Appeal Decision

Appeal Ref: APP/Z4718/W/25/3358981

42 A Station Road, Fenay Bridge, Kirklees, Huddersfield HD8 0AD

- The appeal is made by Mr Gary Oldroyd against the decision of Kirklees Metropolitan Council.
- The application Ref is 2024/70/92497/W.
- The application sought planning permission for the erection of one dwelling and associated works without complying with a condition attached to planning permission Ref 2020/62/93329/W, dated 12 February 2021.

Elevations to Proposed Dwelling			
Grounds of 42a Station Road			
Fenay Bridge			
HD8 0AD			
Date	August 24	Dwg no	Scale
Dwn By		BR 01 B	A3 - 1:100

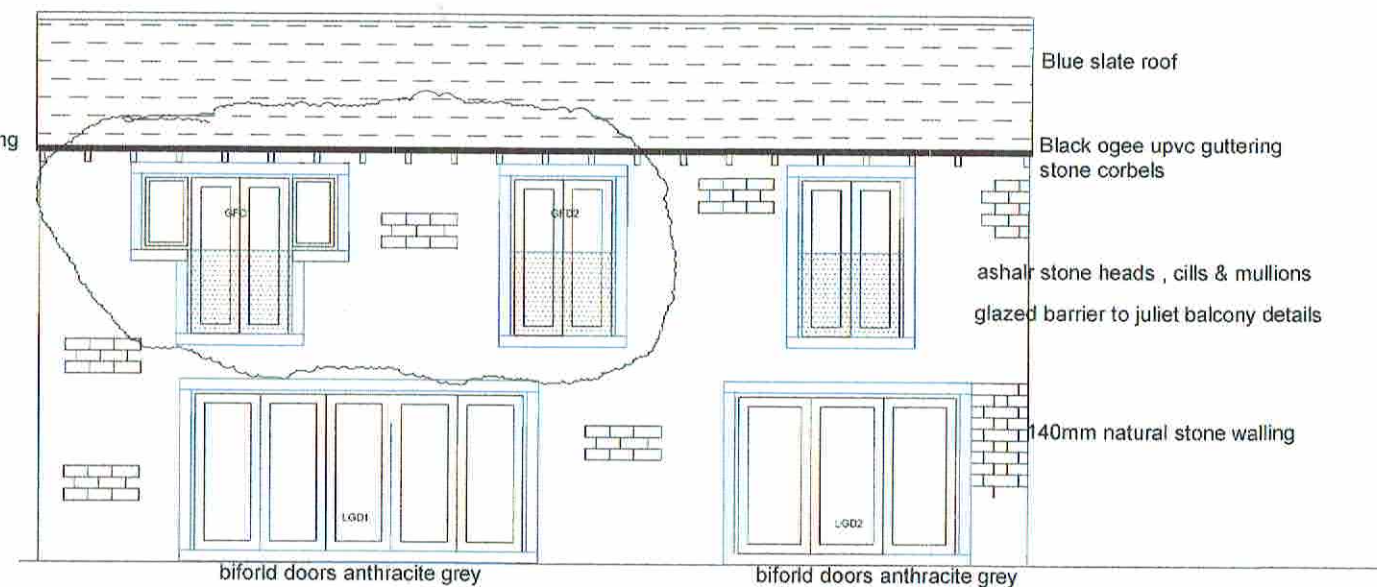
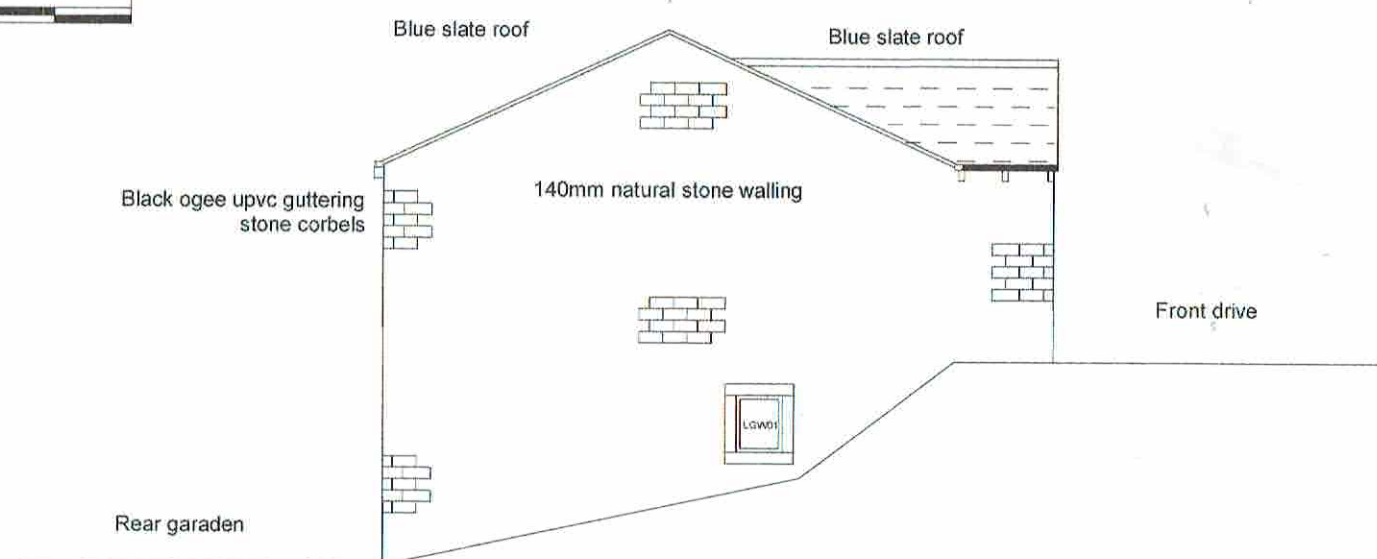
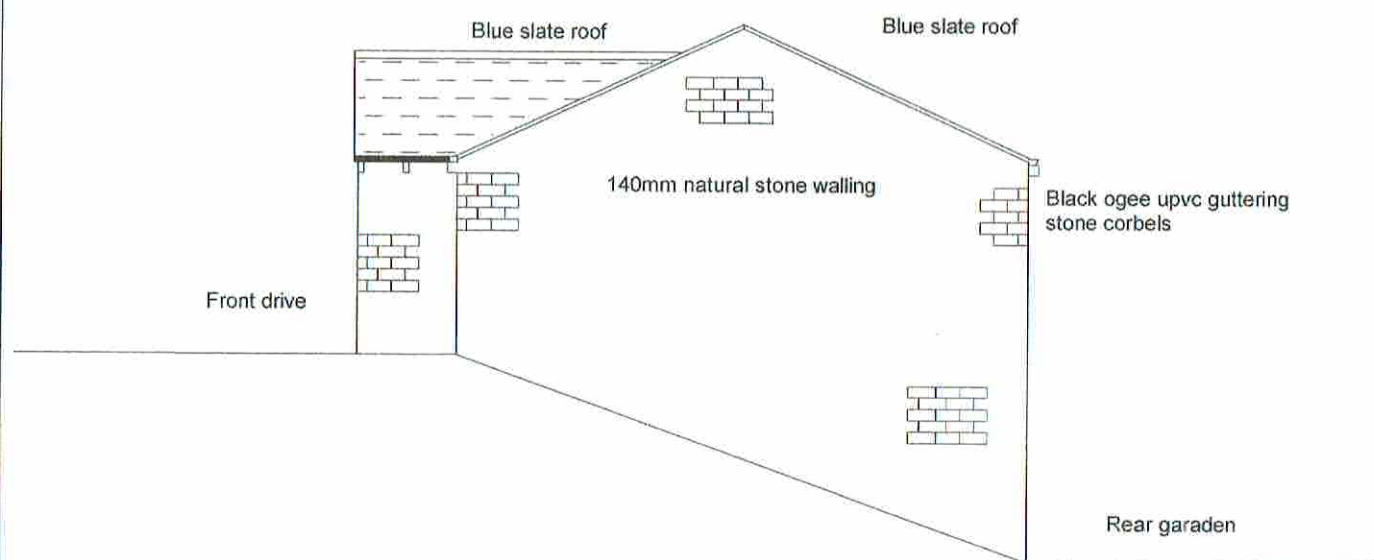
13. However, the appeal scheme would replace the approved car parking area at the side of the dwelling – accessed on the 2021 permission and 2024 variation schemes from the higher ground levels at the front of the dwelling – with a sideways extension of the upper ground floor level portion of the building towards No. 42. Although the previously approved lower ground floor side elevation and low wall around the car parking area would still present a substantial vertical wall towards the boundary with No. 42, the additional height of a full gable elevation

would project above the existing hedge. Whilst that hedge is both reasonably tall and dense, the combination of the full height gable and proximity to No.42 would be such that this element of the building would have a significant physical and visual presence and would loom over No. 42, harmfully so.

14. Furthermore, the plans indicate that the dwelling lies due south of the rear of No. 42, and slightly set-back from it. The combination of the siting and alignment of the dwellings relative to each other, differences in ground levels and the greater proximity of the bulkier gable elevation to No. 42 would be such that there would be a materially greater degree of overshadowing and loss of direct sunlight to the private areas at the rear of No. 42. That the proposed amendments would retain the narrow gap between the dwelling's footprint and No. 42 would not offset the greater height and proximity of the extended (upper) ground floor and its extended side extension gable elevation.

15. Taking these aspects together, I concur with the Council's assessment that the proposed amendments and revisions to the approved dwelling, and specifically the additional built element at (upper) ground floor level closest to No. 42, would cause material harm to the living conditions of occupiers of that property. That harm would be felt in terms of outlook and daylight and sunlight.

Proposed Garage
Grounds of 42a Station Road
Fenay Bridge HD8 0AD

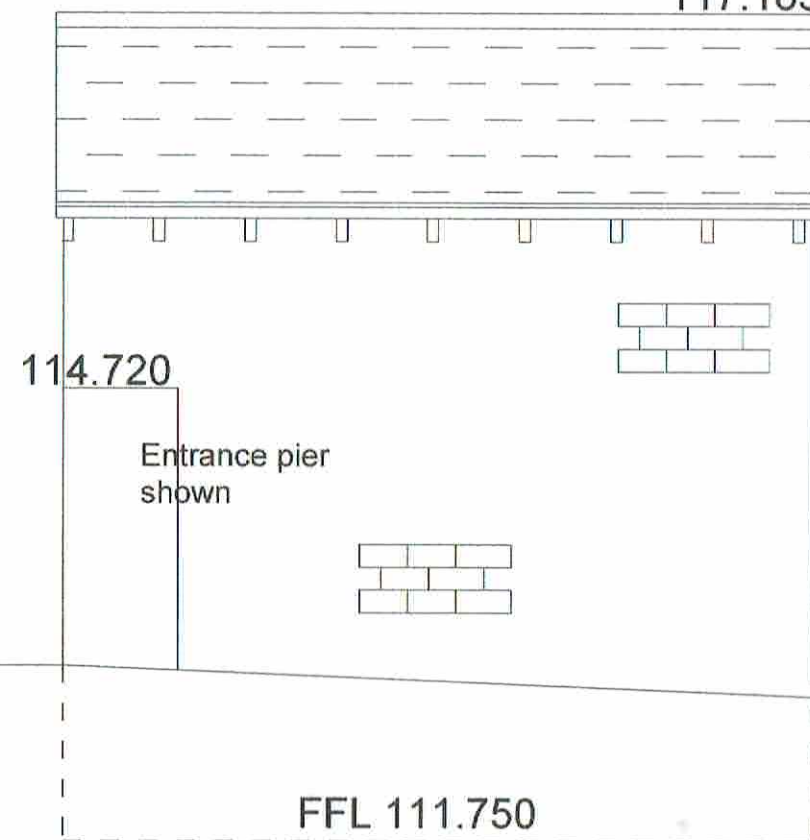
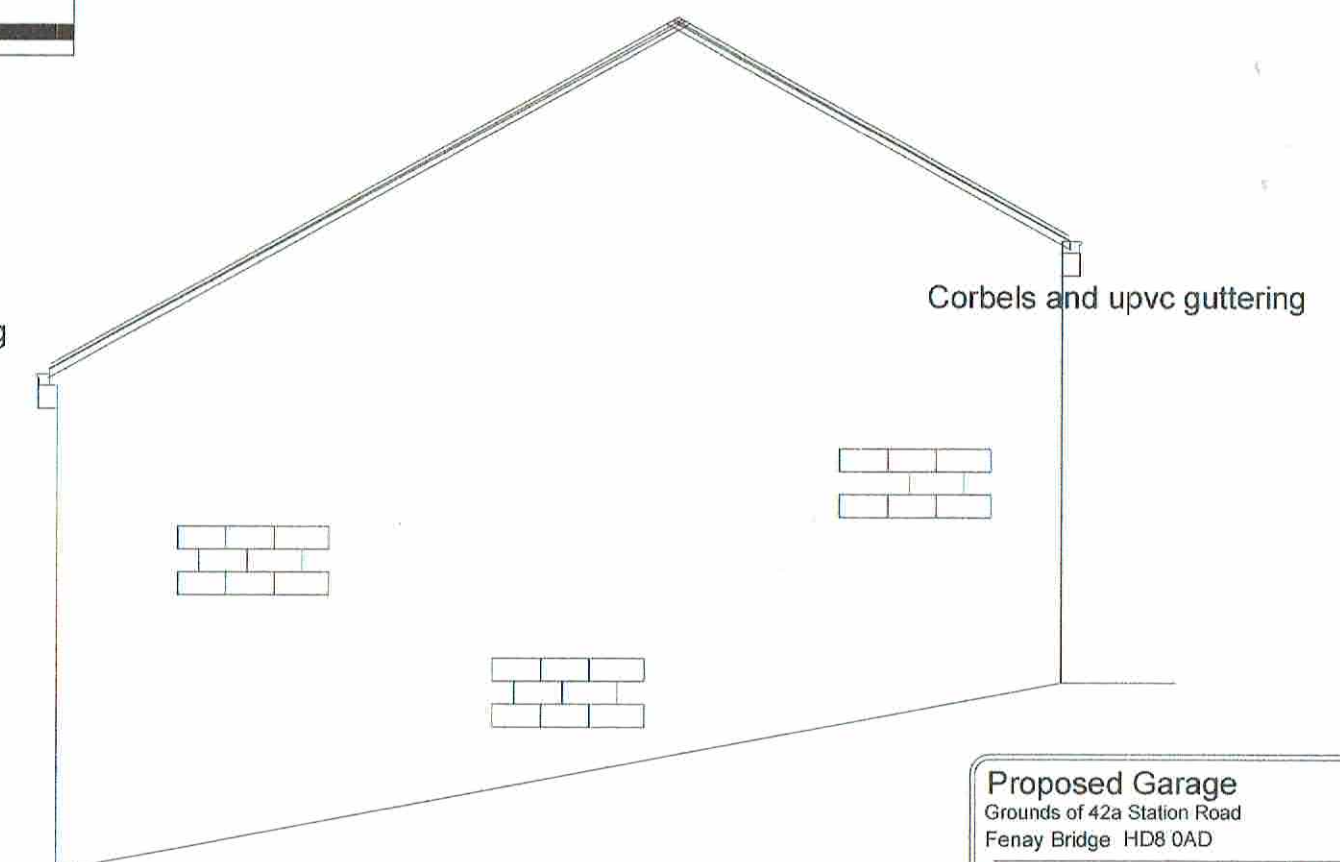
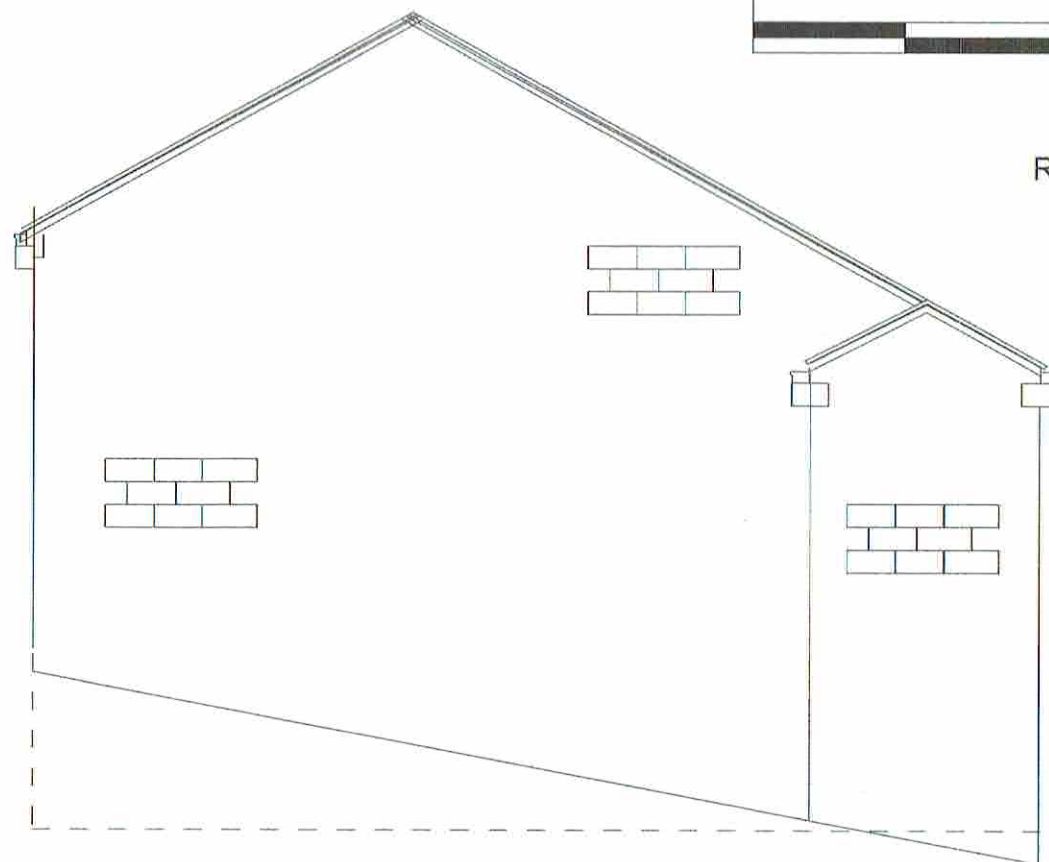
9. However, the proposed detached garage would sit more prominently within the site in a forward position closer to the site entrance. Whilst it would not be positioned directly adjacent to site's Station Road frontage, it would nevertheless be clearly visible from it. Unlike the dwelling, it would not be seen from distance. Rather, its attempt to respond to the slopes within the site would render it unduly bulky in context and wouldn't take advantage of those prevailing slopes to minimise the height and bulk of its flank and road-facing elevations.

10. Whilst I do not find that harm would arise from the dwelling in terms of its effect on the character and appearance of the surrounding area, the proposed detached garage would be an unduly and harmfully bulky and incongruous feature within the Station Road streetscene. Kirklees Local Plan (KLP) Policy LP24 states that good design should be at the core of all development proposals within the Kirklees district. Good design will, it states, be promoted by amongst other things, ensuring that the form, scale and layout of proposals respects and enhances the character of the surrounding area. As a consequence the garage would fail to secure the type of good design that KLP Policy LP24, informed by Principles 5 and 12 of the Council's *'Housebuilders Design Guide Supplementary Planning Document'*³ (SPD) which sets out what the Council considers to be good residential design including, in this instance, the positioning of buildings and the treatment of provision for car parking, and the Framework all seek to achieve.
